NON MATERIAL AMENDMENT APPLICATION – RE: PLANNING PERMISSION CM/6/20/PL, APPROVED 23/07/2020

North Barn, Climping

This NMA concerns amendments to the North Barn, Climping Street, BN17 5RG.

PROPOSED EAST ELEVATION

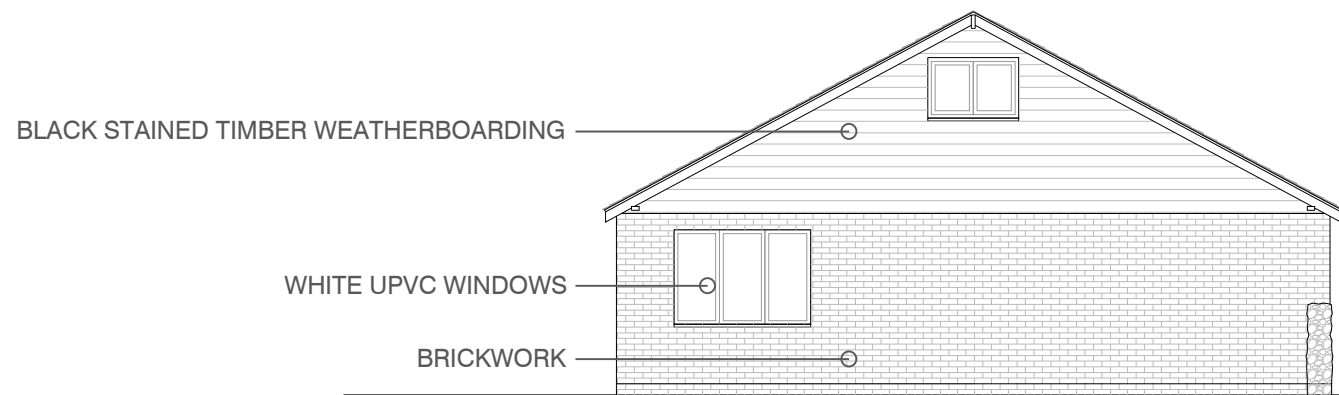
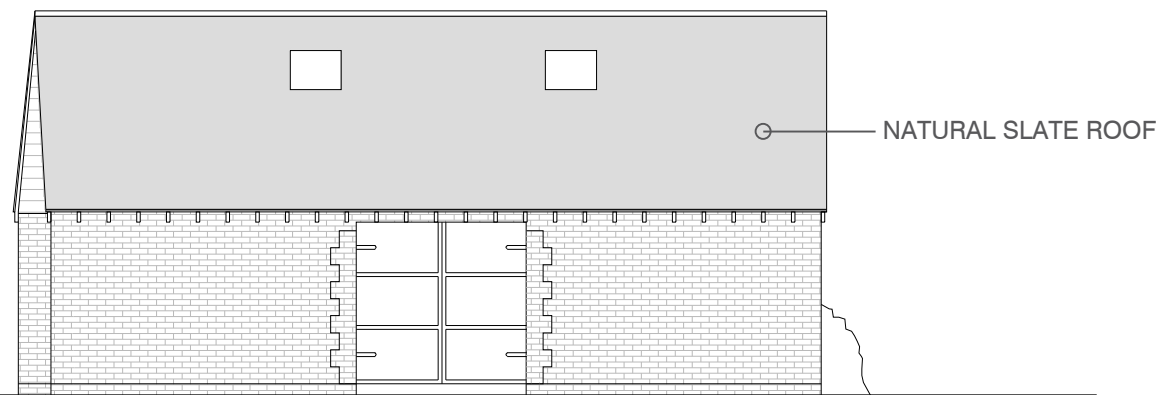
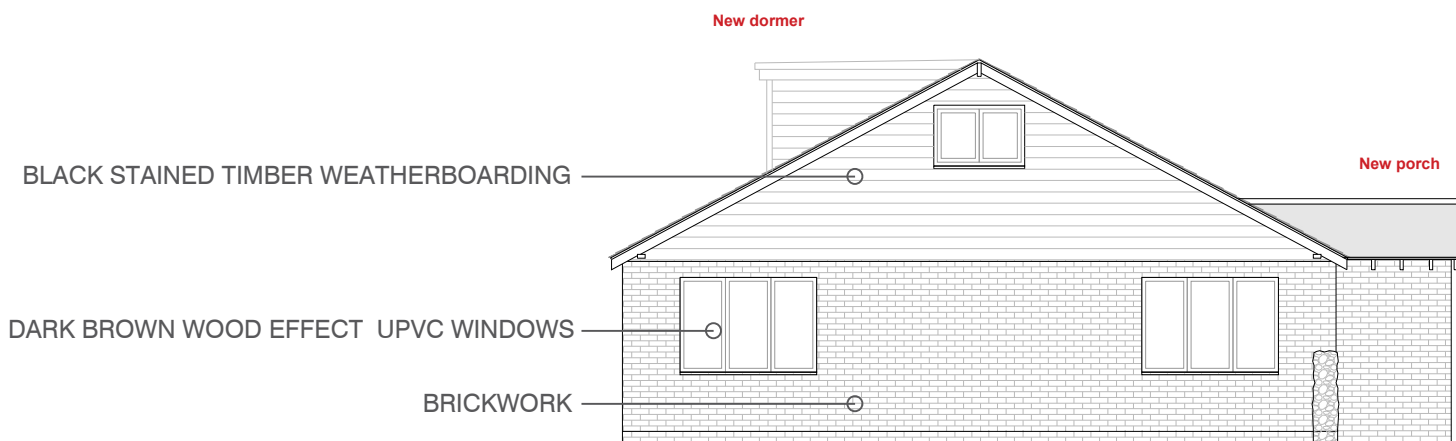
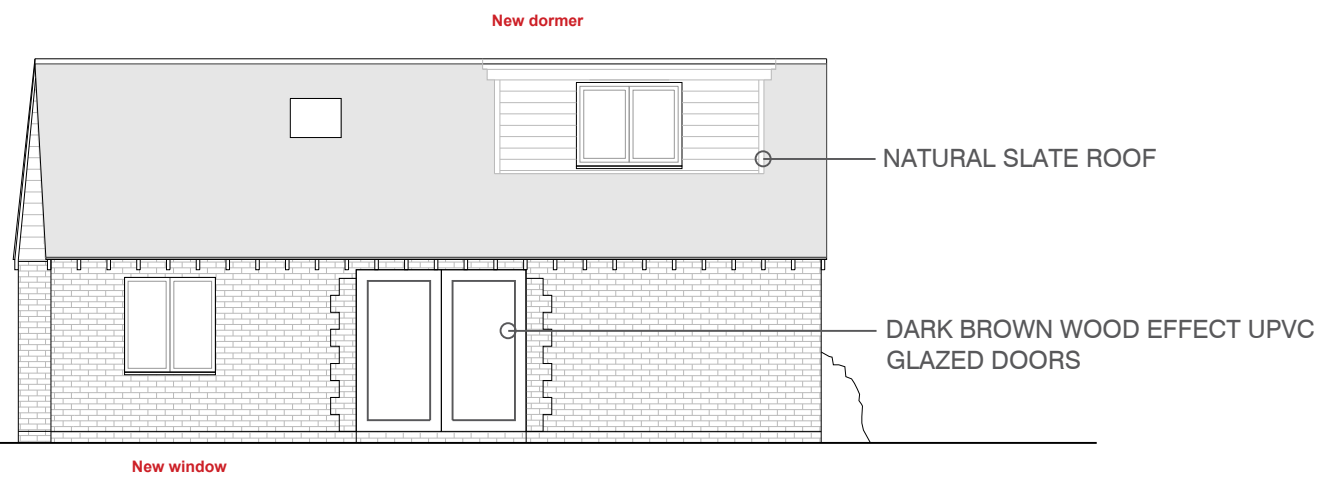
1. The first amendment seeks to add two additional windows to the ground floor, one on the eastern elevation and another on the western elevation. These will ensure adequate light and ventilation is

2. The second amendment seeks to provide a porch to the entrance of the property. This will be constructed of matching brickwork and will have a natural slate roof. A Dark Brown UPVC glazed door to match the approved windows will be used.
3. The final amendment is to provide a dormer window on the eastern side of the first floor to provide better lighting and amenity into the main bedroom. The dormer will allow improved head room and floorspace whilst increasing the amount of natural light. The dormer will be constructed with black stained timber weatherboarding to reflect the approved northern elevation.

Regarding the eastern elevation, the proposed NMA also seeks a small, ground floor window and first-floor dormer window. The other buildings to the east buildings are also within the applicant's ownership, have no doors or windows looking west and would not affect neighbouring property which has a high stairway window which looks north.

PROPOSED GROUND FLOOR PLAN

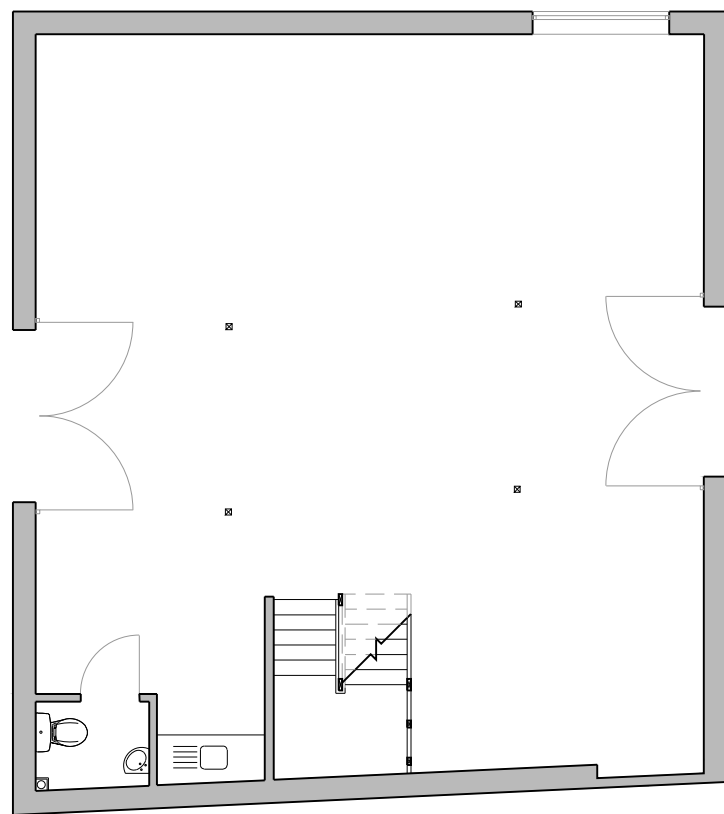
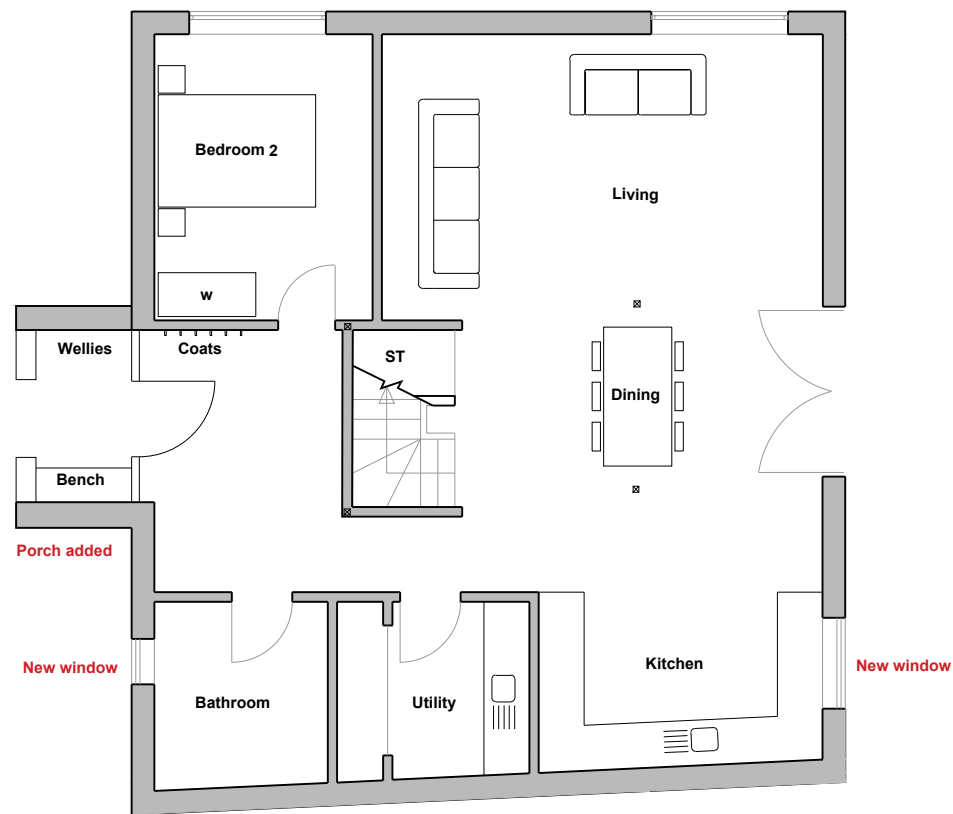
provided in habitable areas of the dwelling. The windows will be dark brown UPVC to match the other approved windows.

PROPOSED WEST ELEVATION

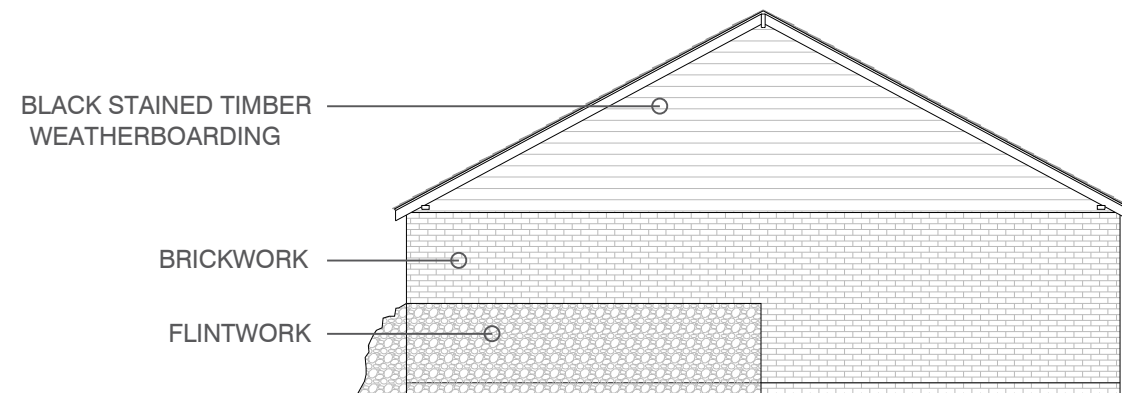
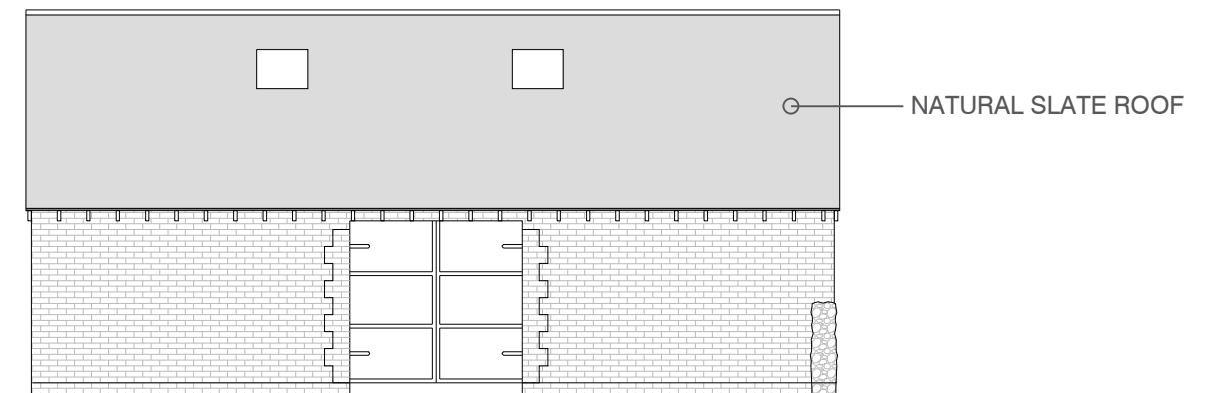
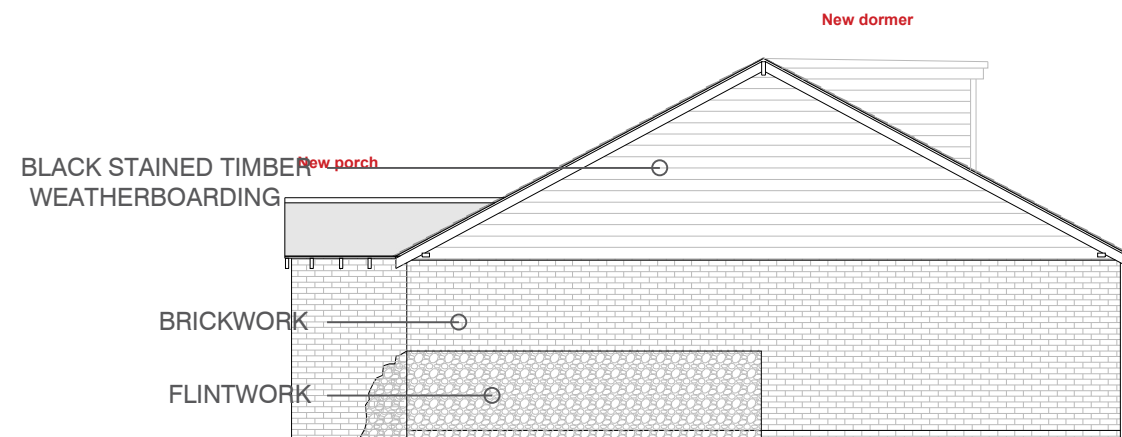
Regarding the proposed new windows, these are to be on the east and west elevations. As you can see on the approved Location Plan, the western elevation is not bounded by a dwelling, instead a large hedge and commercial buildings within the applicants ownership. The position of this window (on ground floor level) will not materially affect the privacy or outlook of this western elevation.
